Our Ref: EN010115

Date: 23 December 2024

Application by Five Estuaries Offshore Wind Farm Limited for an order granting development consent for the Five Estuaries Offshore Wind Farm project

Request for further information

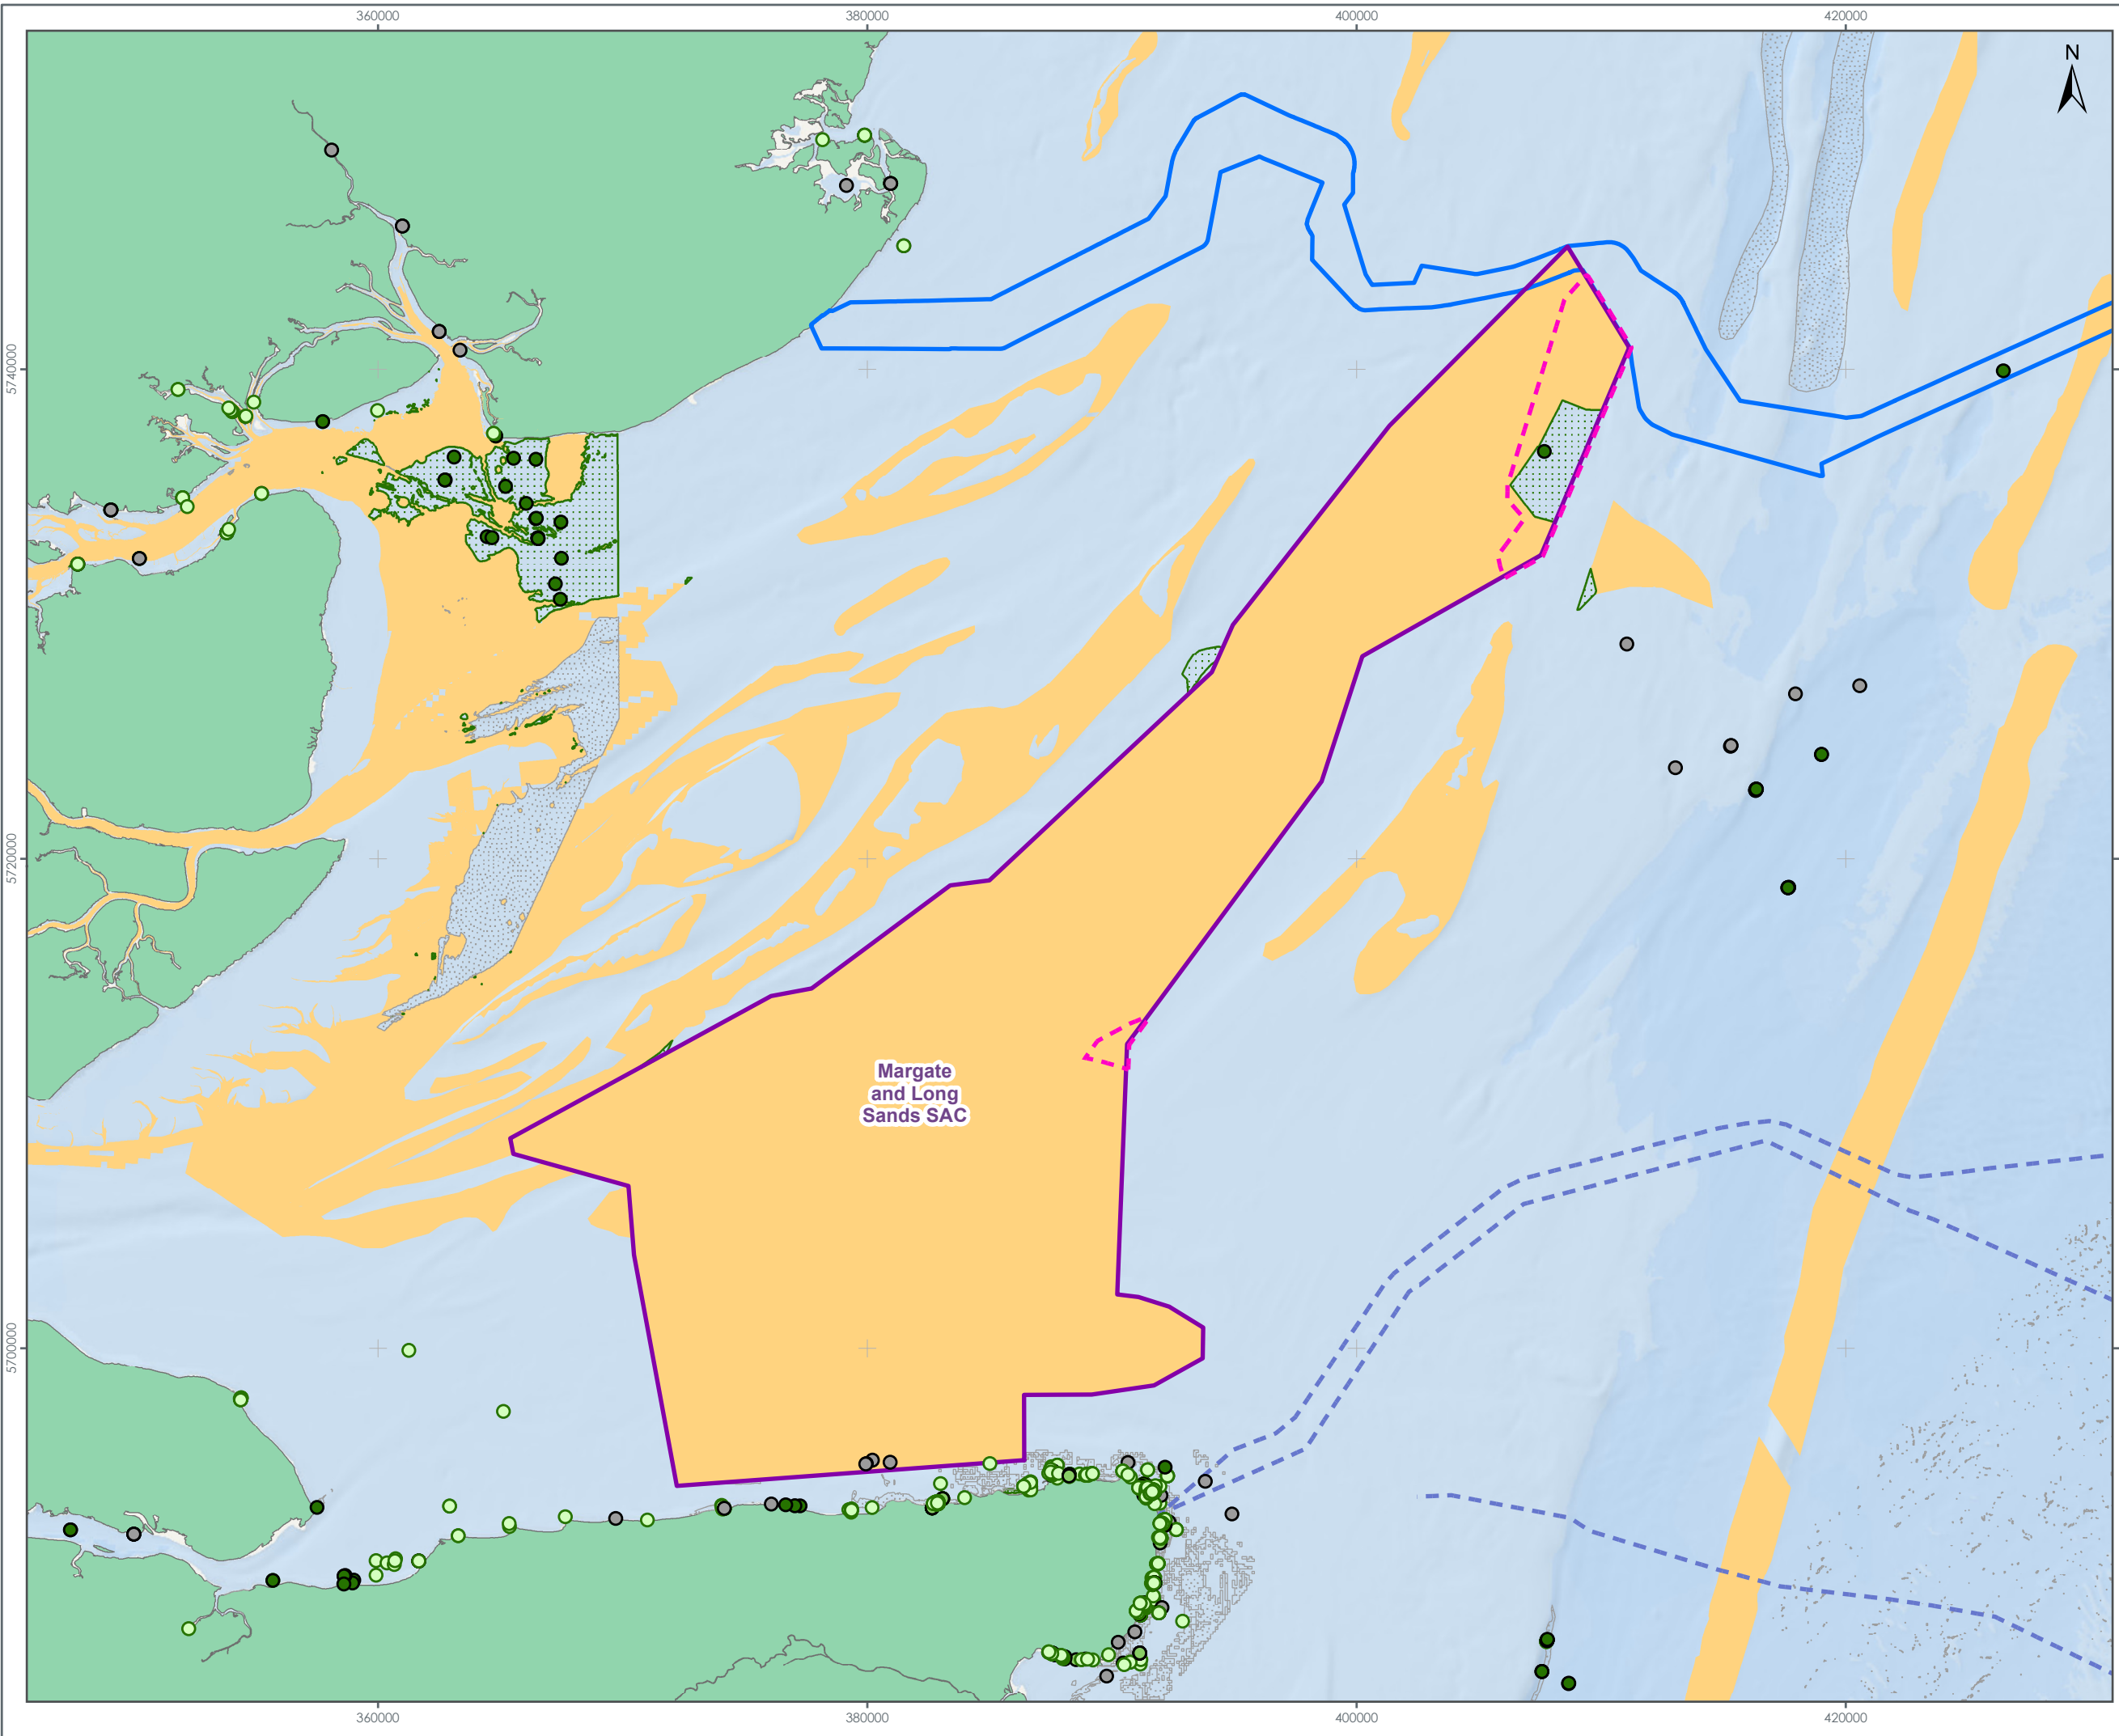
- 2) Paragraph 2.3.7 in the Benthic Compensation Strategy Roadmap (BCSR) [APP-047] states that the location of the final cable route for the Proposed Development will be informed by necessary separation from cables proposed as part of the NF OWF project. What separation distance between the project's export corridor cables would be necessary and how is that distance determined?
